SSD8606 - RESPONSE TO SUBMISSIONS - LOT 23 & 24 HOLLINSWORTH ROAD, MARSDEN PARK

This Response to Submissions (RtS) provides responses to the agency and community submissions received during the public exhibition of the Environmental Impact Statement (EIS) for a warehousing and distribution estate at Lot 23 and 24, Hollinsworth Road, Marsden Park (SSD 8606).

SECTION: EE
SCALE 1:100

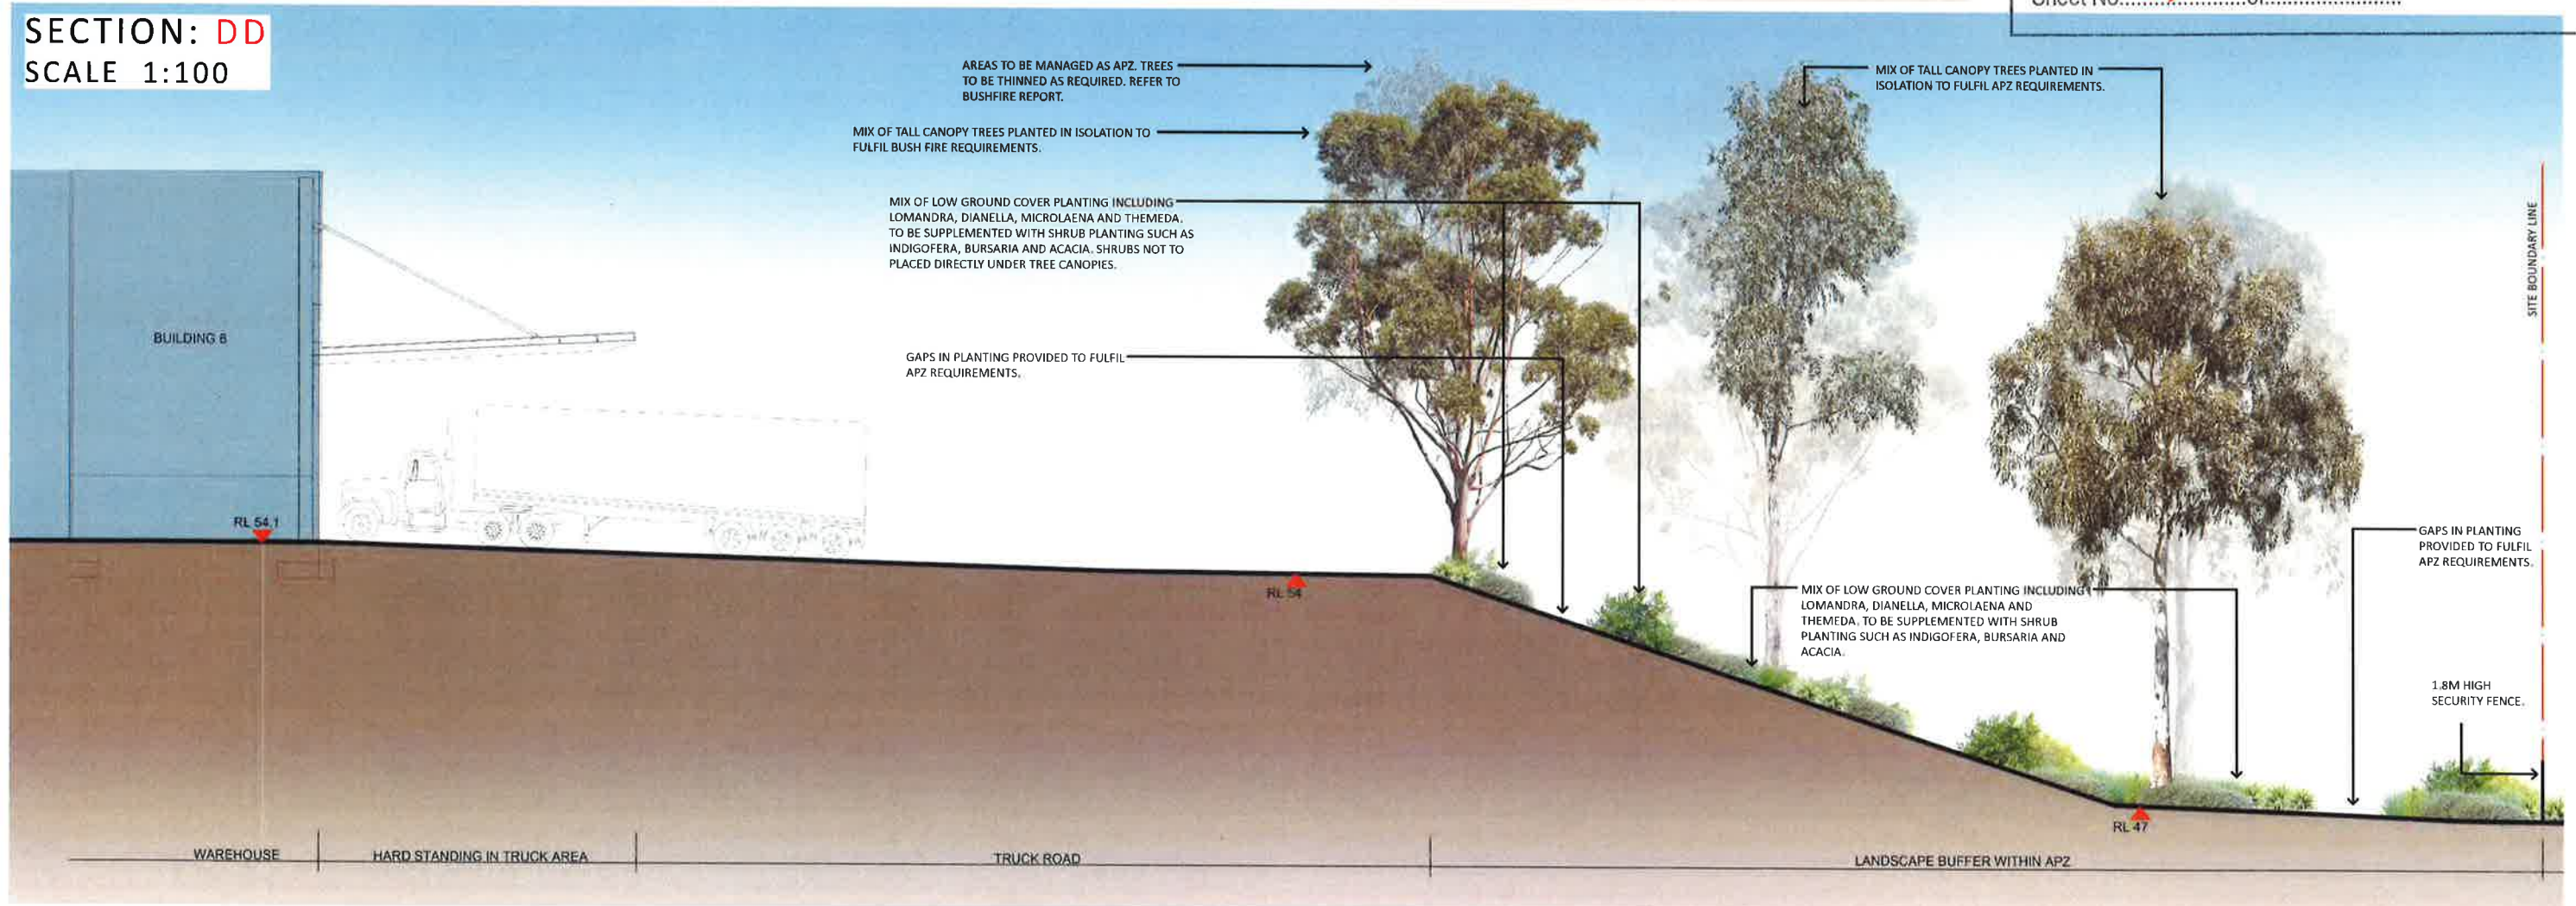
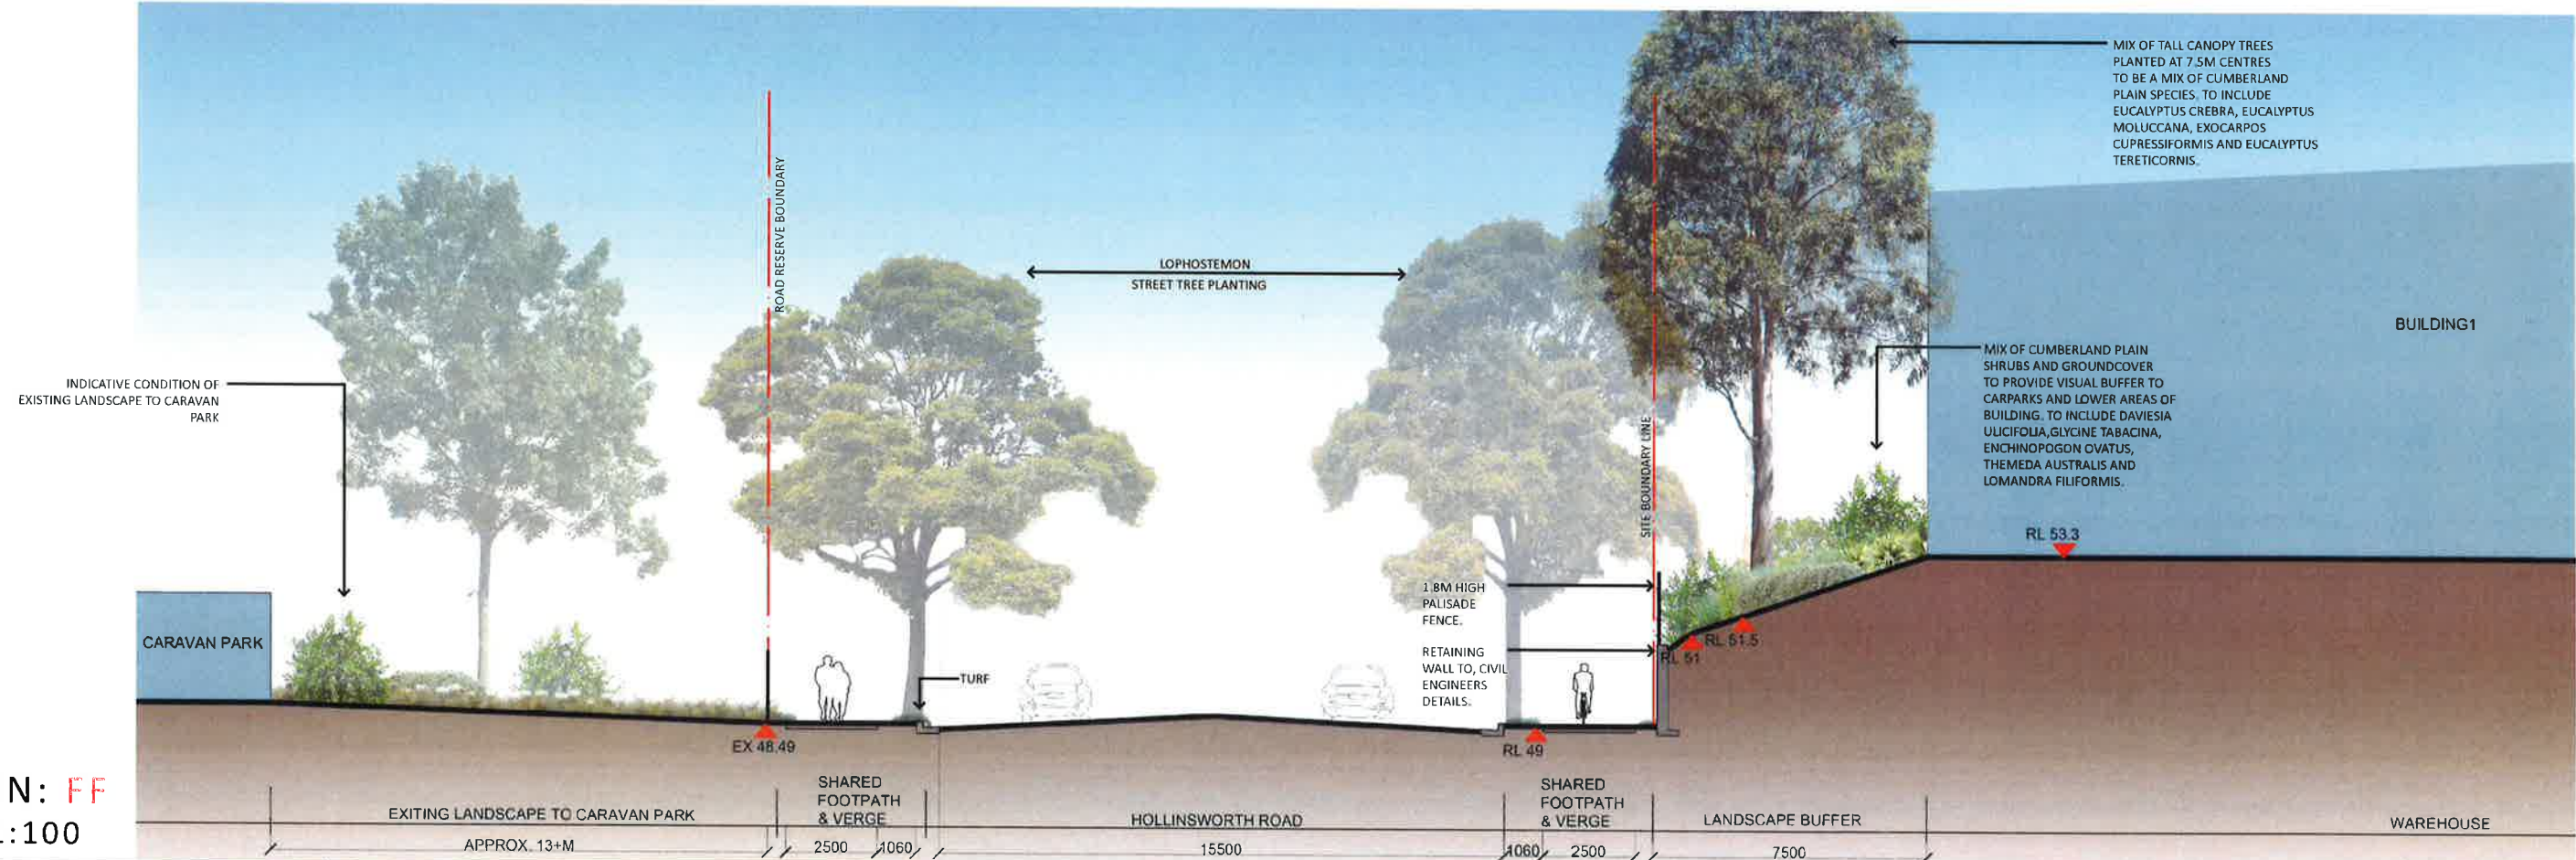
| Item Raised | Proponent's Response |
|--------------------------------------------------------------------------------------------------------------------------------------------------------------------------------------------------------------------------------------------------------|-------------------------------------------------------------------------------------------------------------------------------------------------------------------------------------------------------------------------------------------------------------------------------------------------------------------|
| <p>Section FF of the landscape plans should be amended to also show the Ingenia Estate and full road carriageway of the Hollinsworth Road extension as reflected in the Landscape Site Masterplan. Measurements should be included in the section.</p> | <p>Section FF has been amended to show the Ingenia Estate, full road carriageway and measurements.</p> <p>Refer to Geoscapes 'Landscape Sections: EE & FF' drawing SSD-10 dated 7 March 2018.</p> |
